DEVELOPMENT FACILITATION TEAM
SUPPLEMENTAL SUBMITTAL

PROJECT NO. 2023-009688
Application No. SI-2024-00597

Attn. : DFT Chair
Cc. : Reviewers
Re. : **SI-2024-00597 – SITE PLAN DFT**
 : **2026 Central SW**
Project No. : **PR-2023-009688**

01 EXTERIOR ELEVATION
EAST FACADE
SCALE: 1/8" = 1'-0"

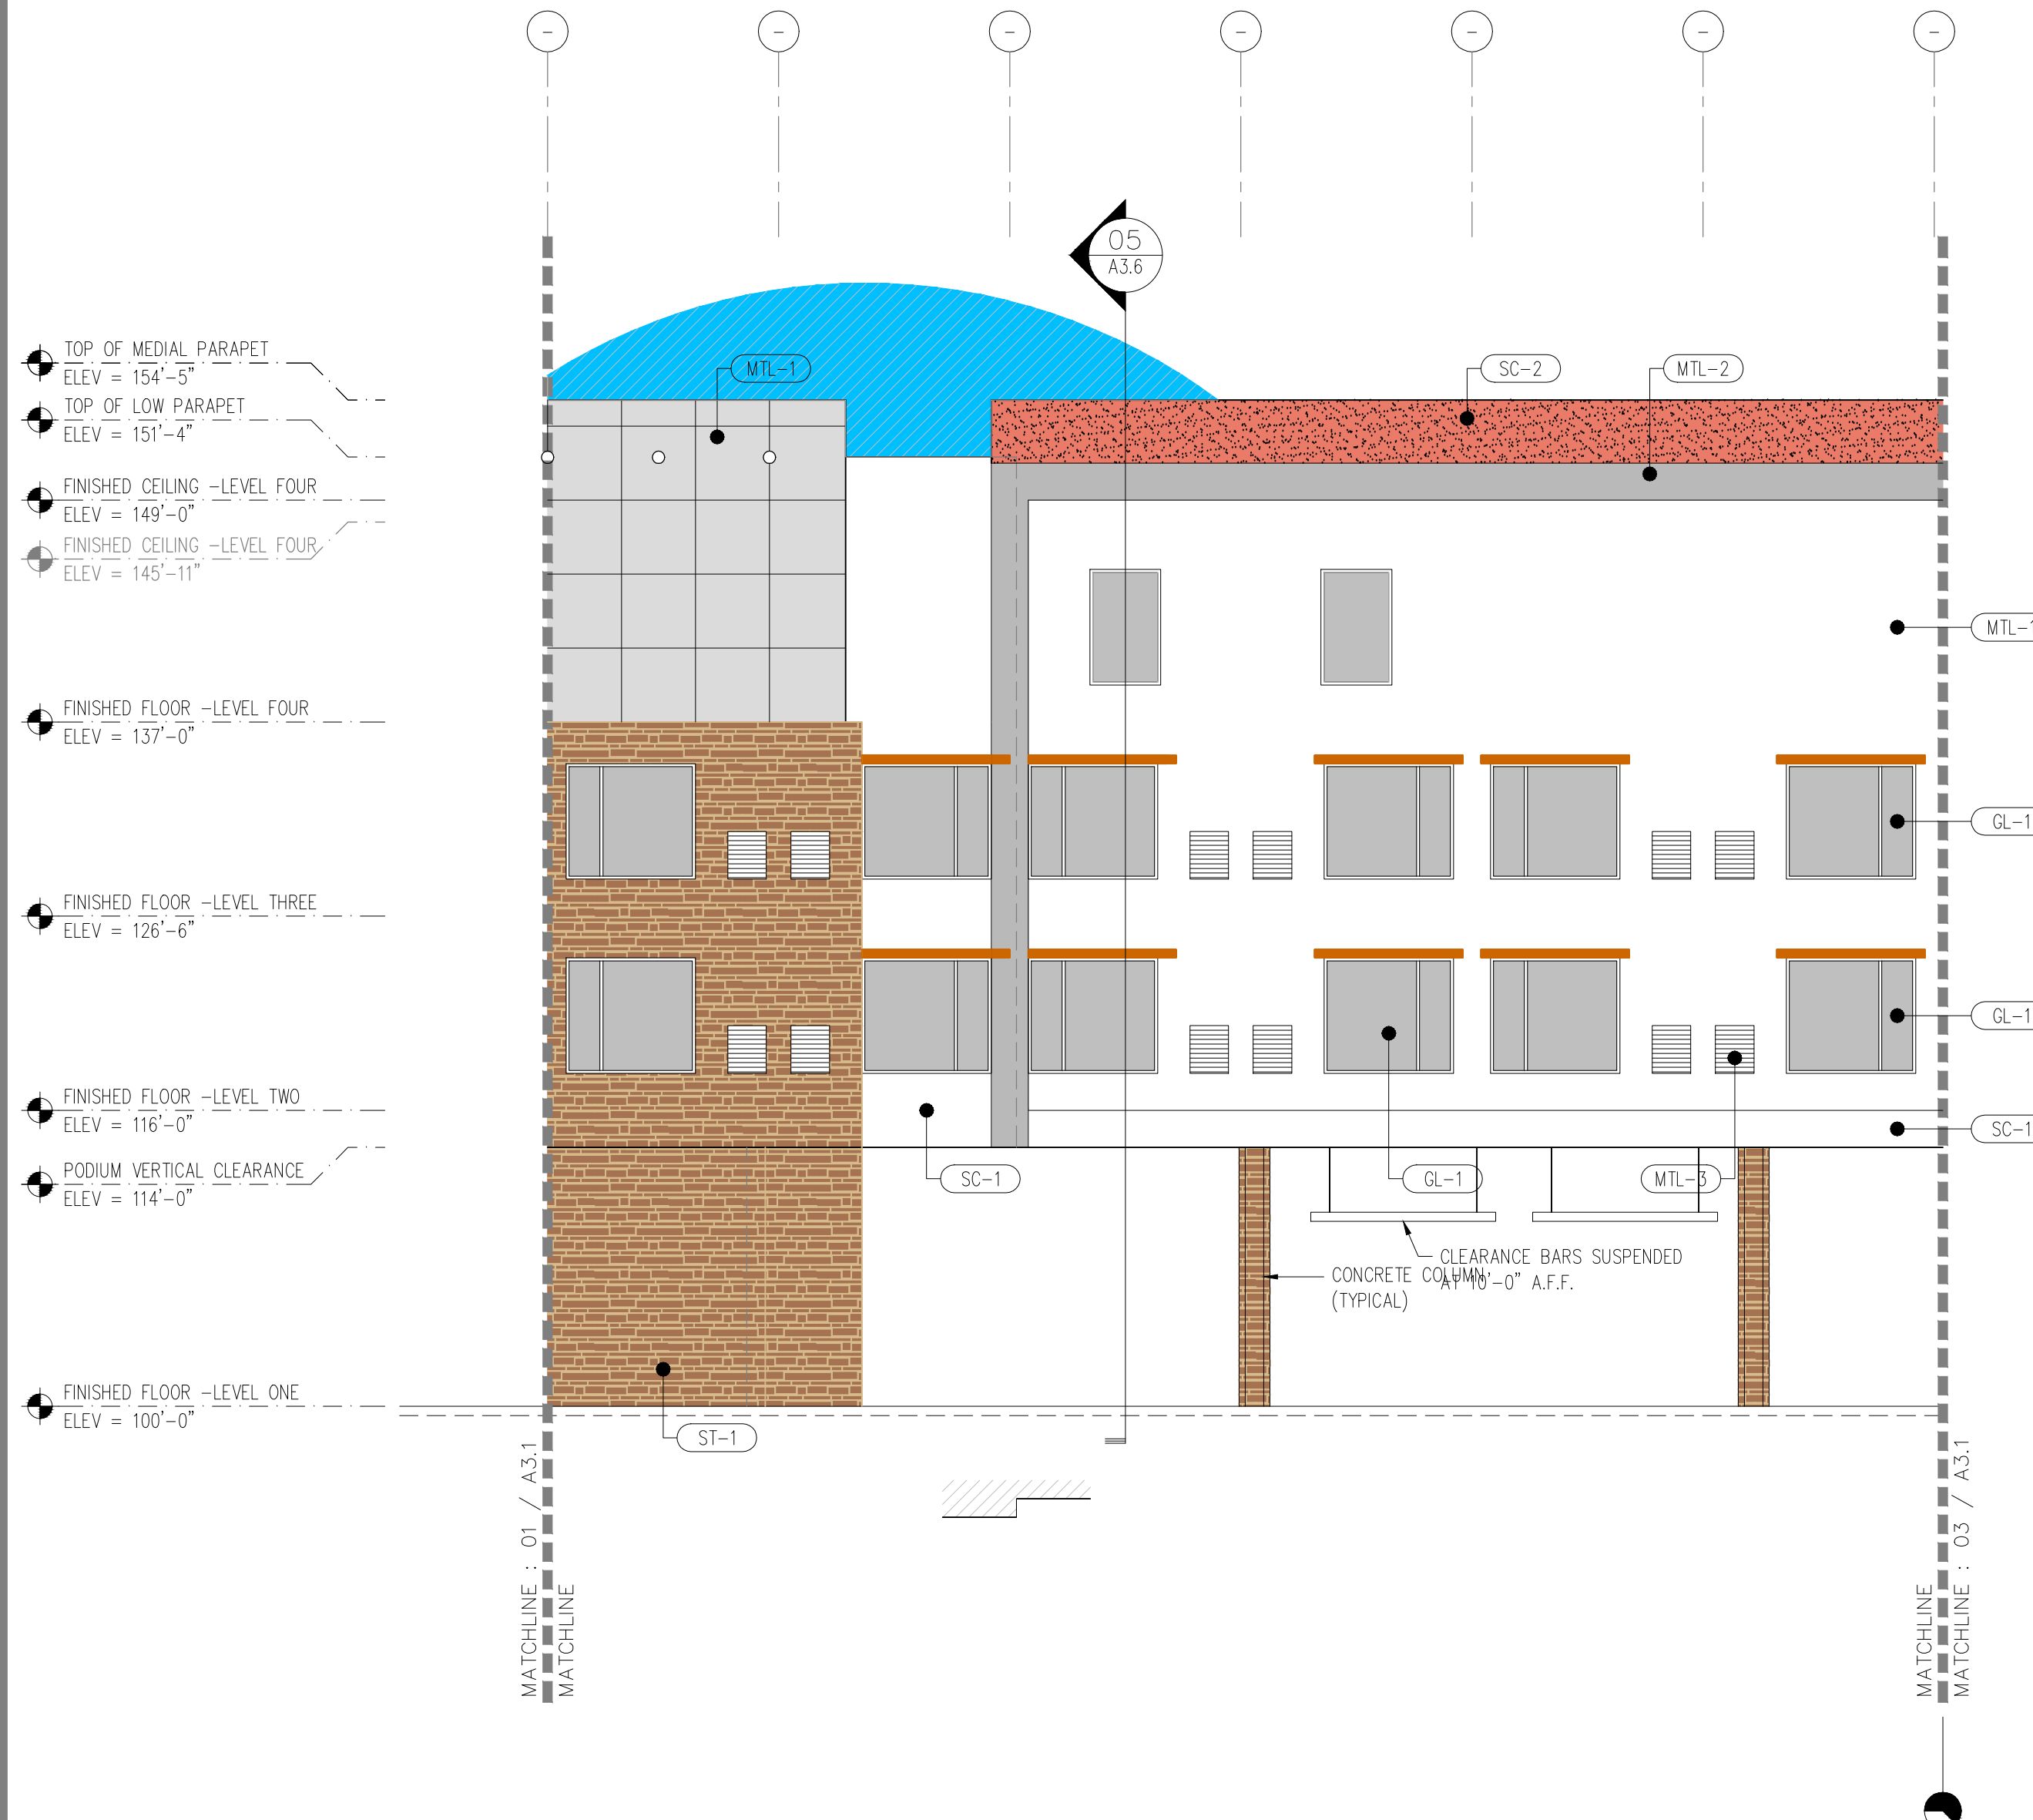
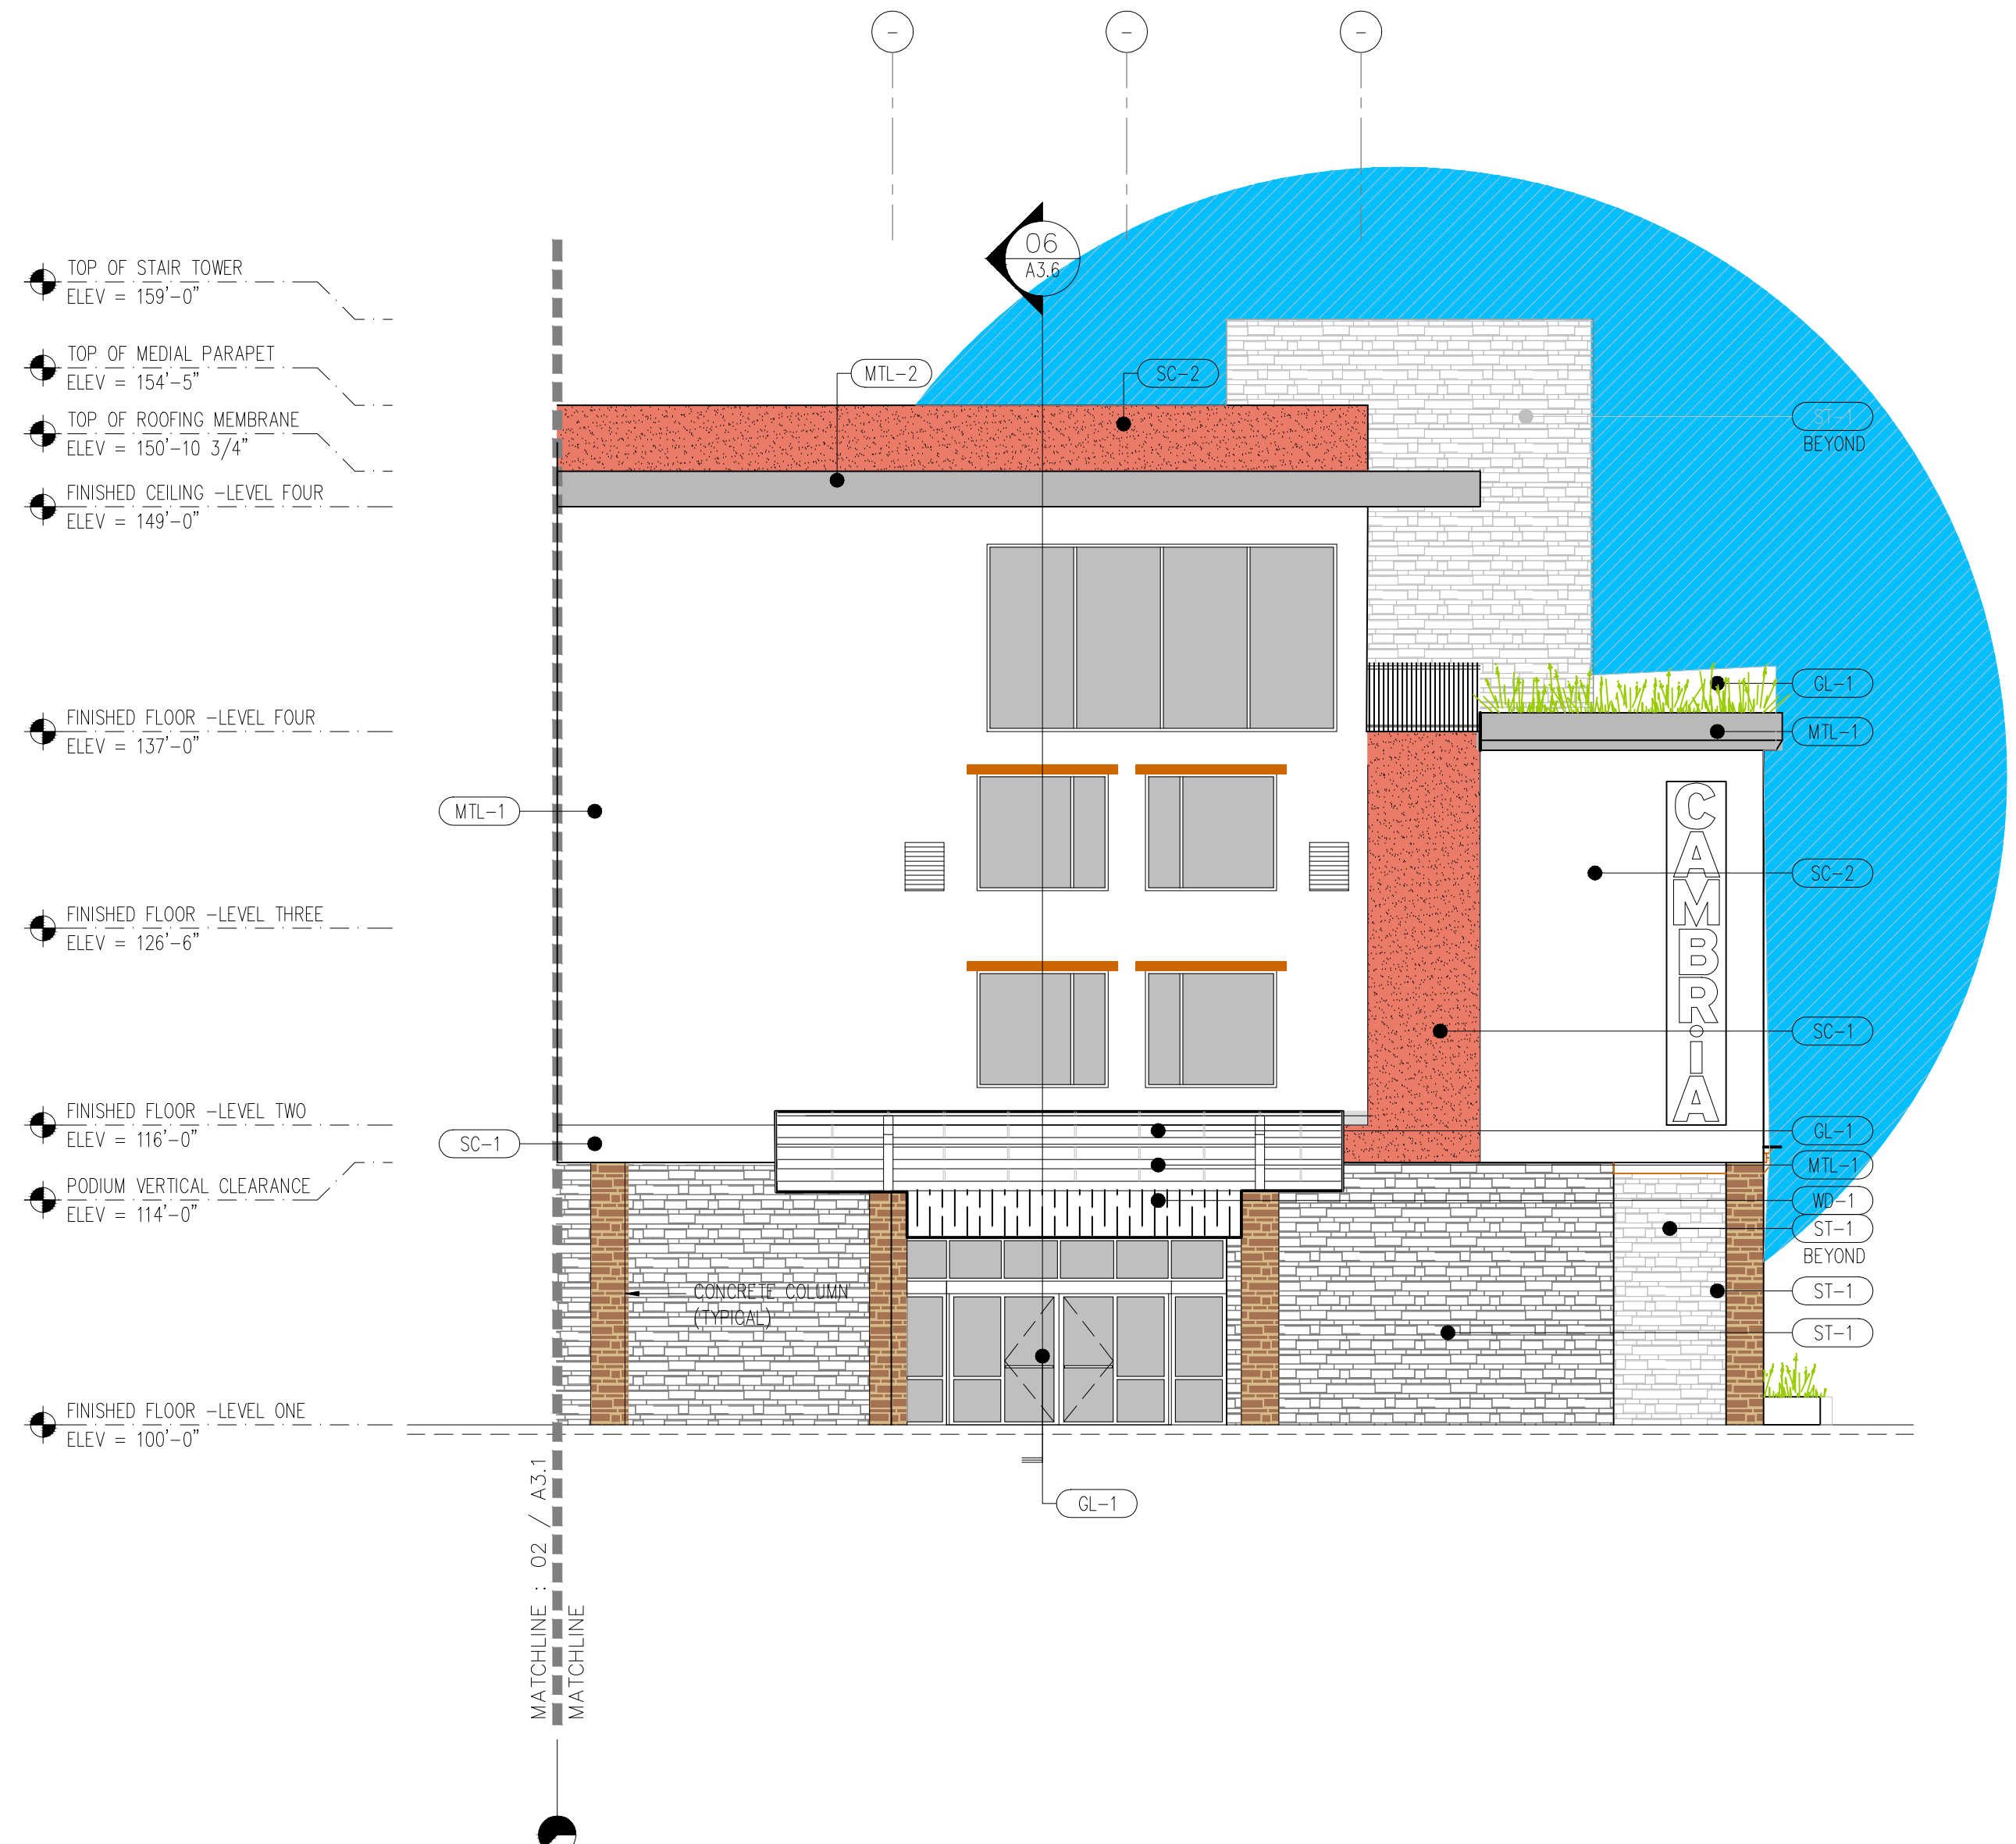
12 **Comment** - 5-5(G)(3)(b) No horizontal length of any façade shall extend longer than 40 feet without the inclusion of architectural elements such as decorative grillwork, louvers, translucent screens, alternating building materials, projection of lintels, portals, and other external features to avoid visual monotony. A change in color alone does not satisfy this requirement. Confirm compliance.

Response: Concur. The elevations have some lintels shown, but we have added some other architectural elements in the stretches of elevation that are more than 40' to avoid visual monotony.
